**Consultation Response from KC,
Trees**

2021/93565 Land Adjacent, Hazeldene House, Stoney Bank Lane, Thongsbridge, Holmfirth, HD9 7LZ

Removal of condition 5 (Construction Method Statement) on previous permission 2020/91213 for erection of detached dwelling and formation of new access (modified proposal)

Date Responded: 27/10/21 | Responding Officer: NG | Responding Ref: TPO 19/86

**Tree Protection Plan to BS5837:2012 at:  
 Hazeldene, New Mill**

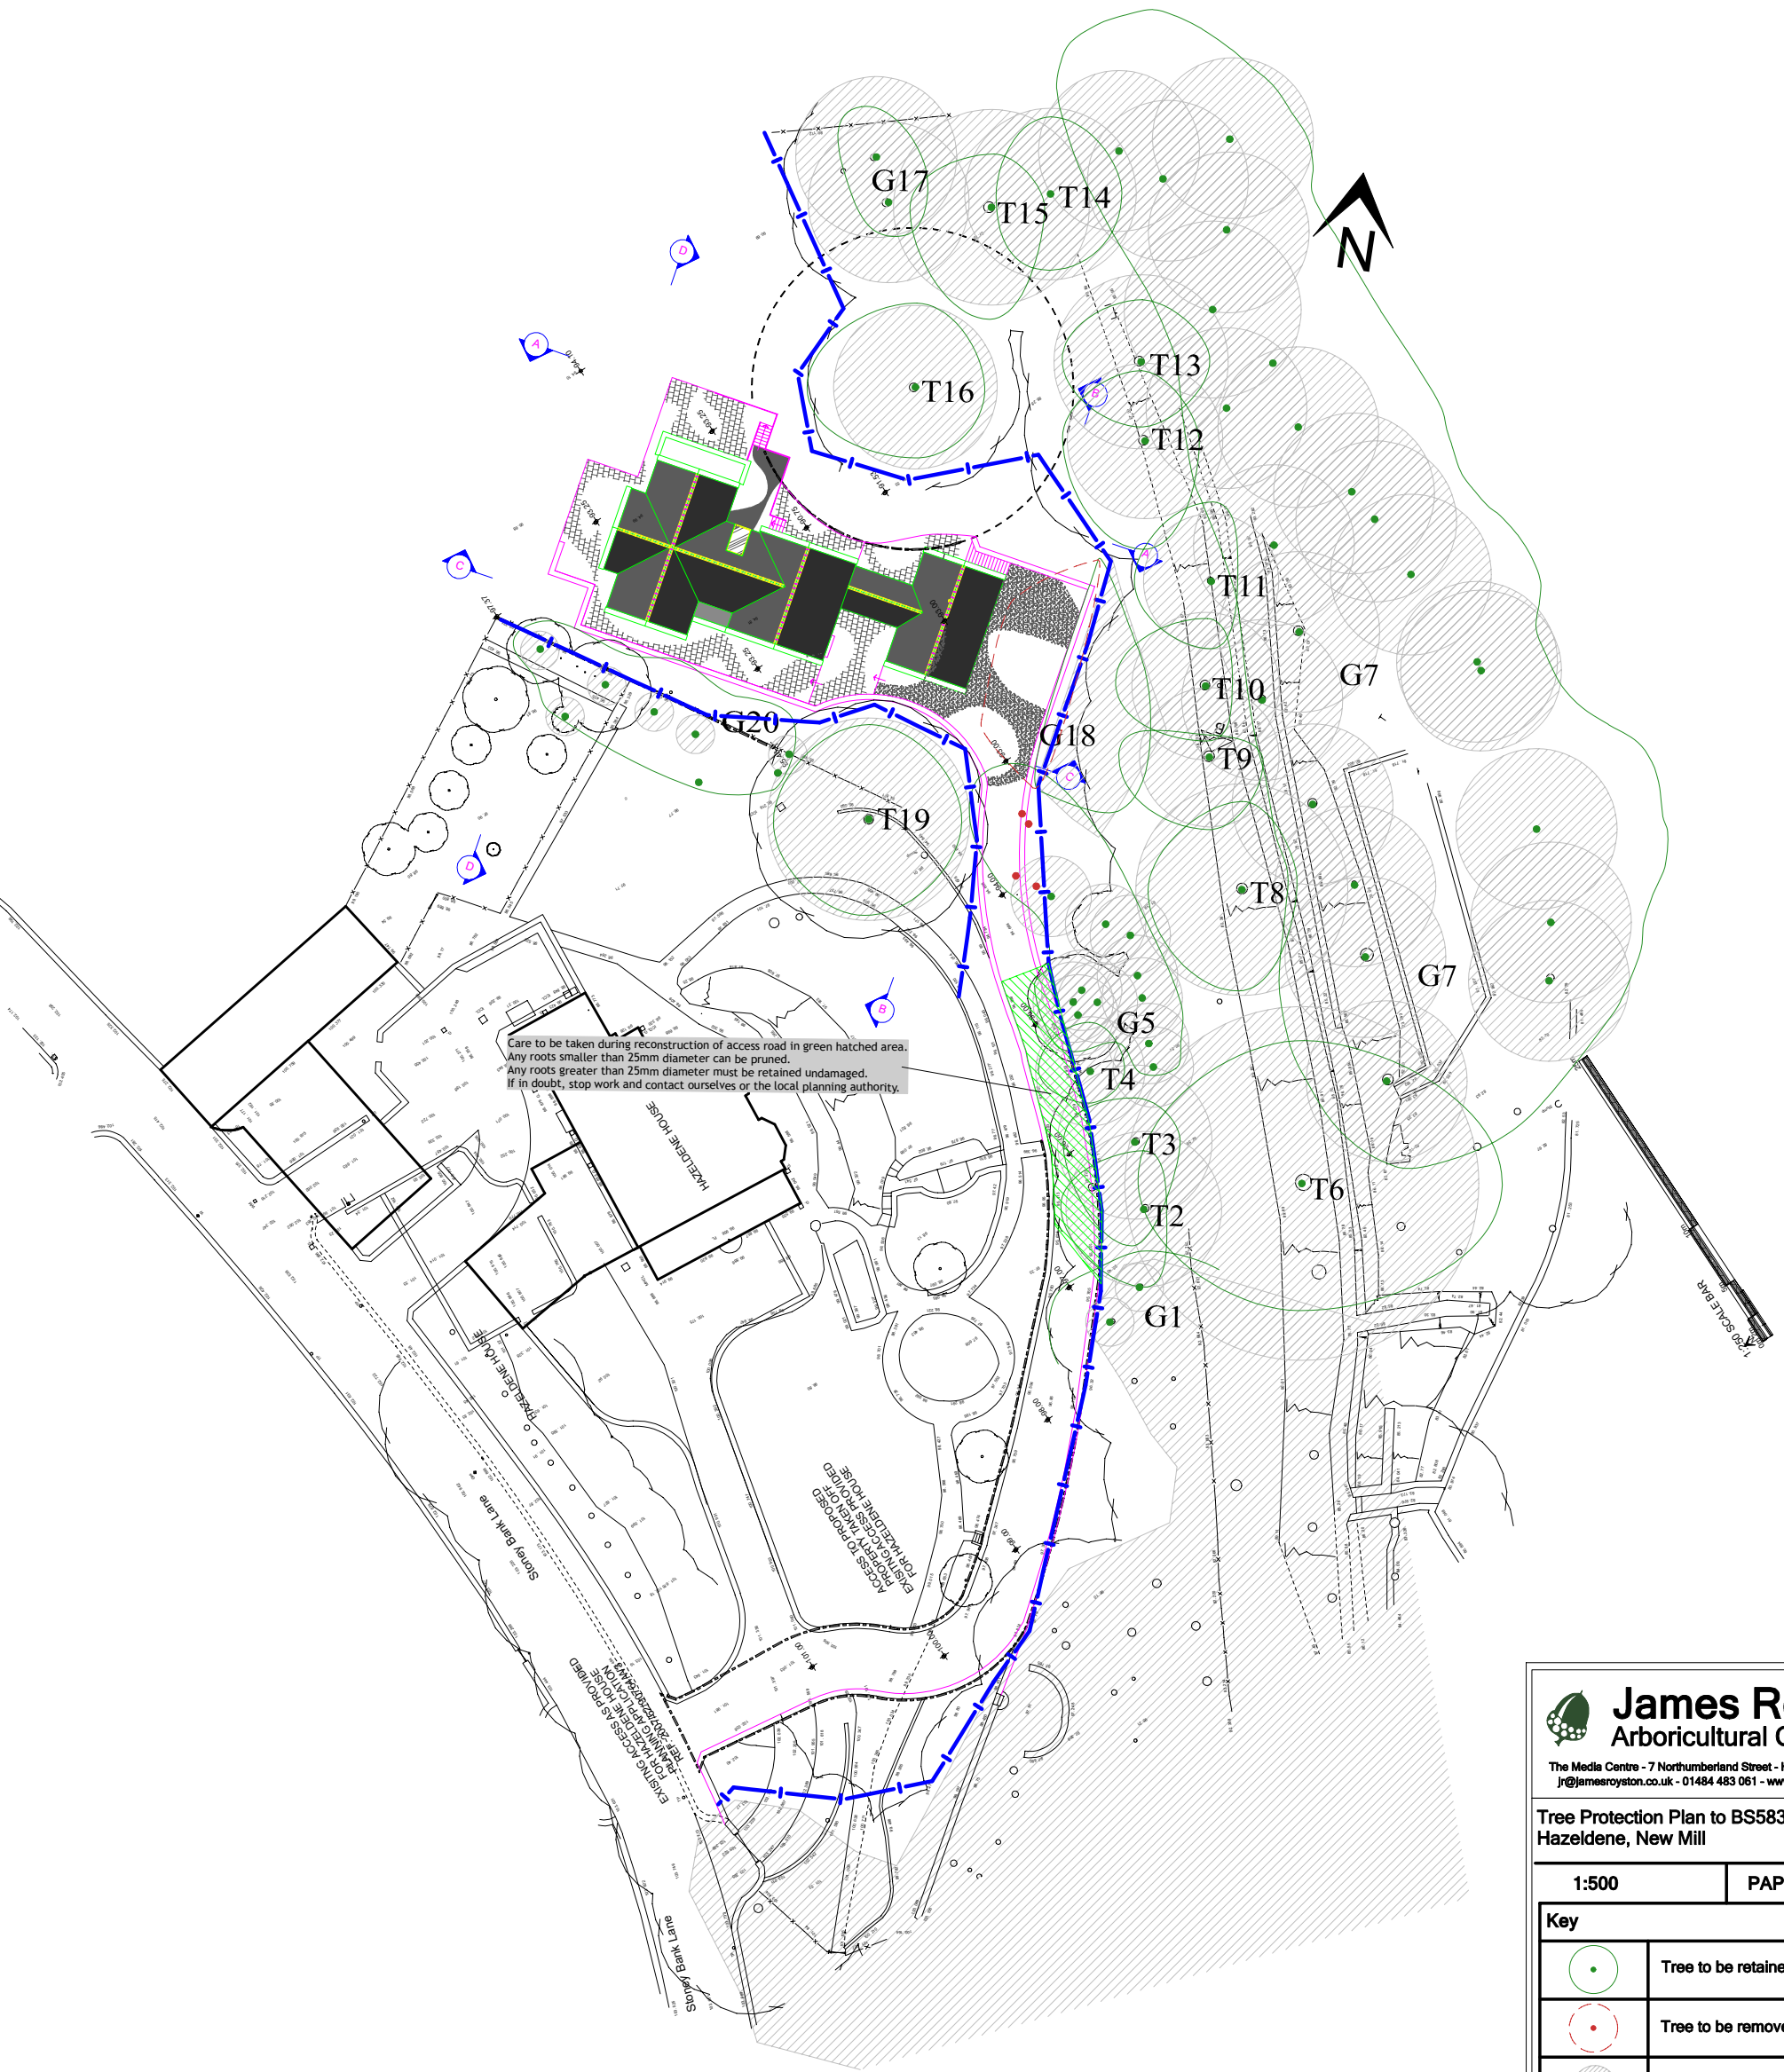
The AMS submitted with the original application hasn't been updated so but the layout of the plot or site arrangement hasn't changed so it is still acceptable. Any consent issued should include a condition of compliance with the AMS to ensure the protection of trees on and adjacent to the site.
